Application: SSI 7485

I write regarding the proposed modification to M4-M5 Link, Mod 2 The Crescent overpass and changes to pedestrian infrastructure in North Annandale, Rozelle and Rozelle Bay Foreshore area.

Figure 4-2 Pedestrian and cyclist bridge infrastructure options

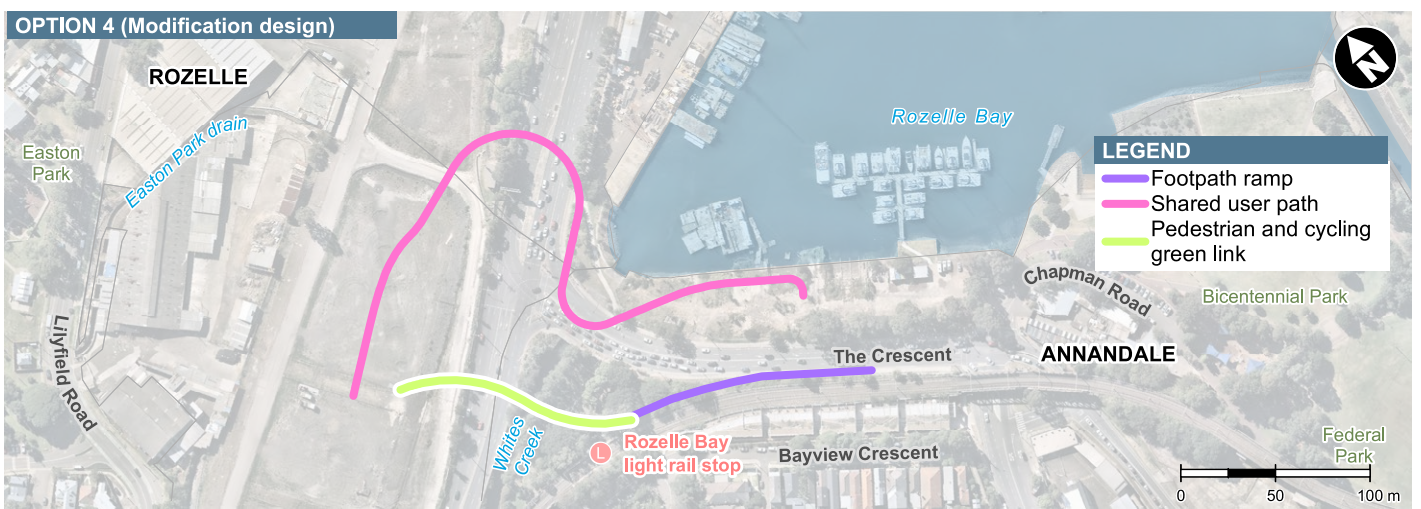
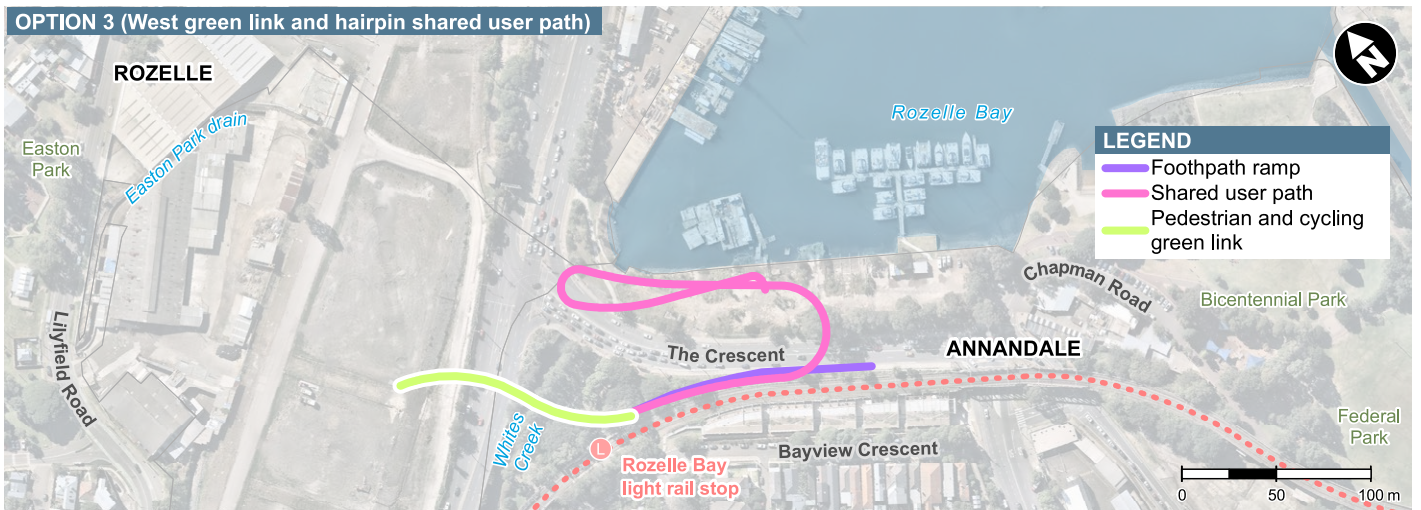
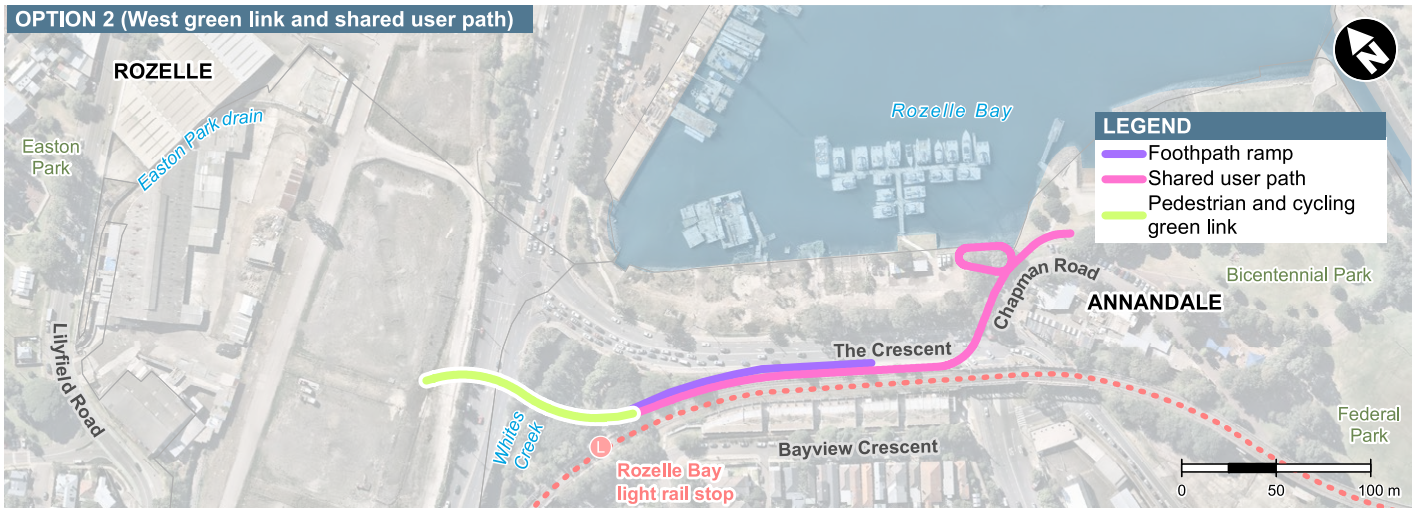
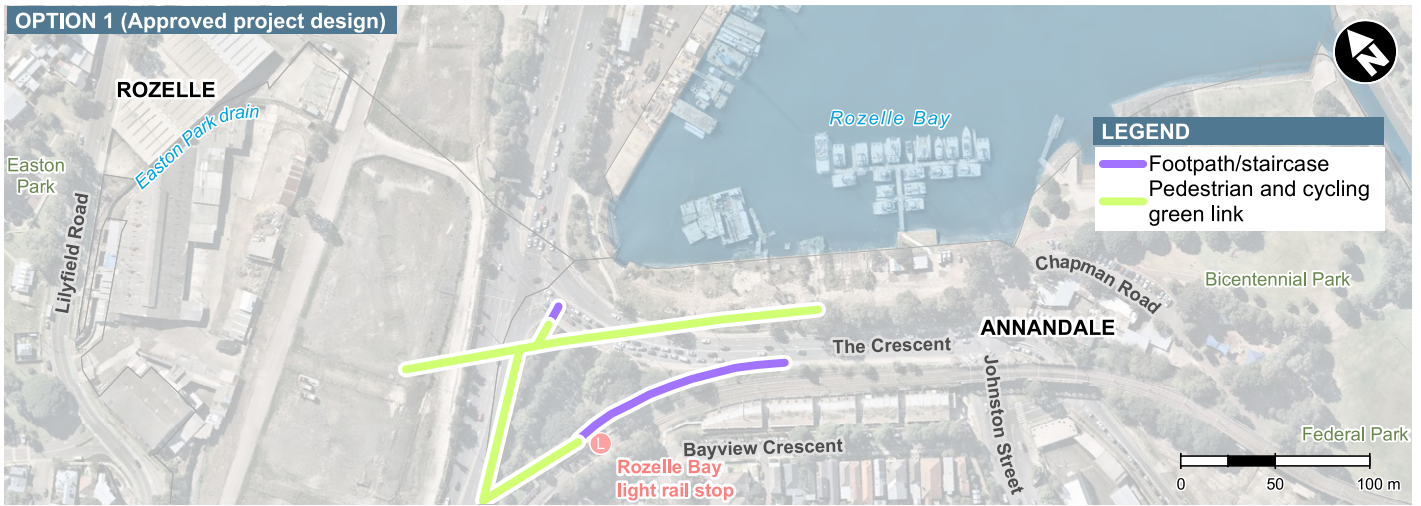
I request RMS work with the community to explore alternate design options to the proposed new car overpass design and the changed pedestrian and cyclist links. I am seeking the reinstatement of the safe, direct access from the approved EIS GreenLink to create a continuous green open space connection from the Rozelle Rail yards and Annandale to the foreshore. The GreenLink was more than just a walk way - it put people central to the design, maximising safety, and providing much needed accessible open space for the community now and into the future Bays Precinct design.

- The significantly reduced safety and increased risk for pedestrians and cyclists with removed access over The Crescent to Bicentennial Park and the increased traffic along Johnson Street.
- Being required to cross five sets of pedestrian lights at The Crescent as my option to reach the foreshore from Annandale or from Rozelle Bay light rail stop.
- Removal of direct active links to the foreshore, cutting the community off from the area and the proposed revitalisation of the entire Bays Precinct, including linking the Light Rail and Bus stops to a Ferry wharf and Metro station.
- Urban and landscape design that is being built before a finalised Masterplan for the area.
- Traffic changes that limit movements around the suburb and create further congestion in the local streets of Annandale, Forest Lodge, Glebe, Lilyfield and Rozelle with no planning to deal with these.

- Reinstate the GreenLink connecting communities and green open space from Rozelle to Bicentennial Park
- Relocate and design pedestrian and cyclist connections that are continuous, safe and direct.
- Design the modification infrastructure and active links in response to the character of the suburbs, the location of the foreshore and it's potential future development.
- Provide pedestrian and cyclist paths that maximise people safety and do not force them onto busier streets, unsafe concrete plazas and caged walkways.
- Integrate active and direct connections to all active transport – including the future Metro West and Foreshore Ferry Wharf
